Fields for Farming – ISH1 Response Agenda Item 9 – Other (Traffic)

9. Other Matters Raised not specific to the agenda – Traffic

Plate 4.2 – Compounds and Haul Routes Location Plan

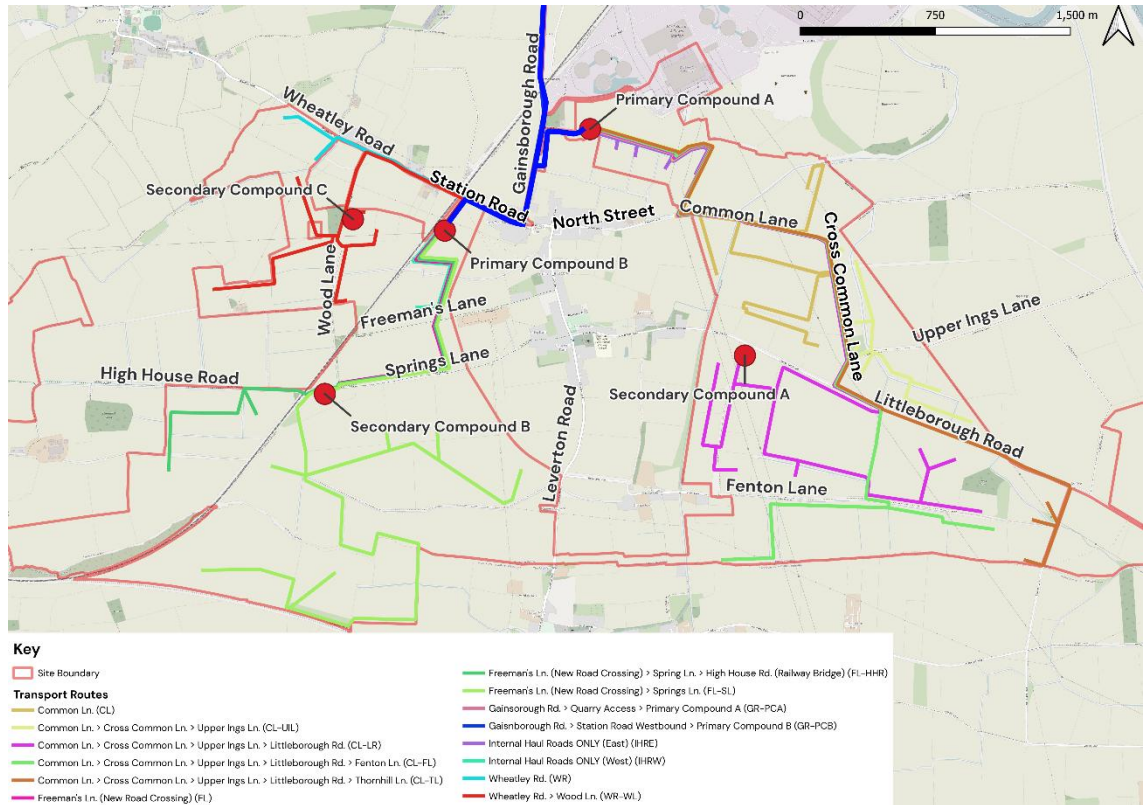
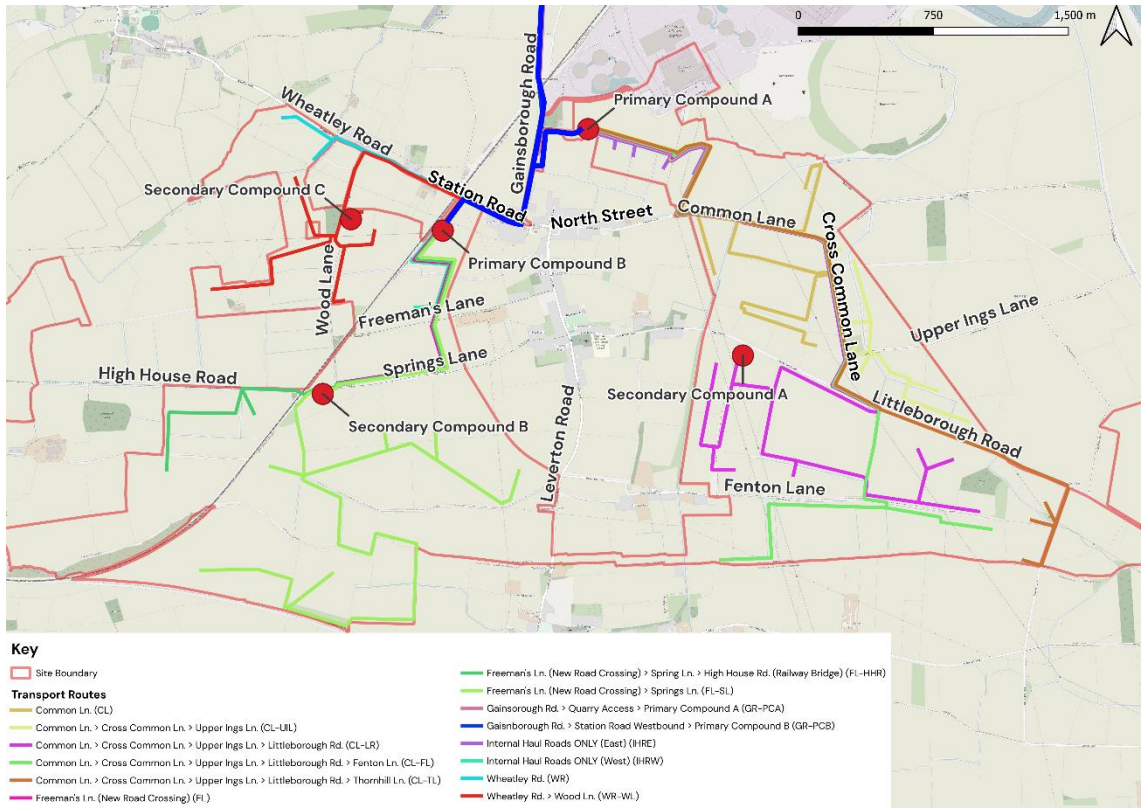
The CTMP suggests that HGV's will delivery all materials to two construction compounds, one on Gainsborough Road (not even classified as a C road), the second through the village to the West on Station Road.

A (unknown) number of vehicles will continue into the village and travel through the part of the village to the second compound on Station Road. What is not clear is how the equipment will then be transported from this second compound to the fields to the West of the railway line as shown in EN010163-000042-2.5 Field Numbering Plan.
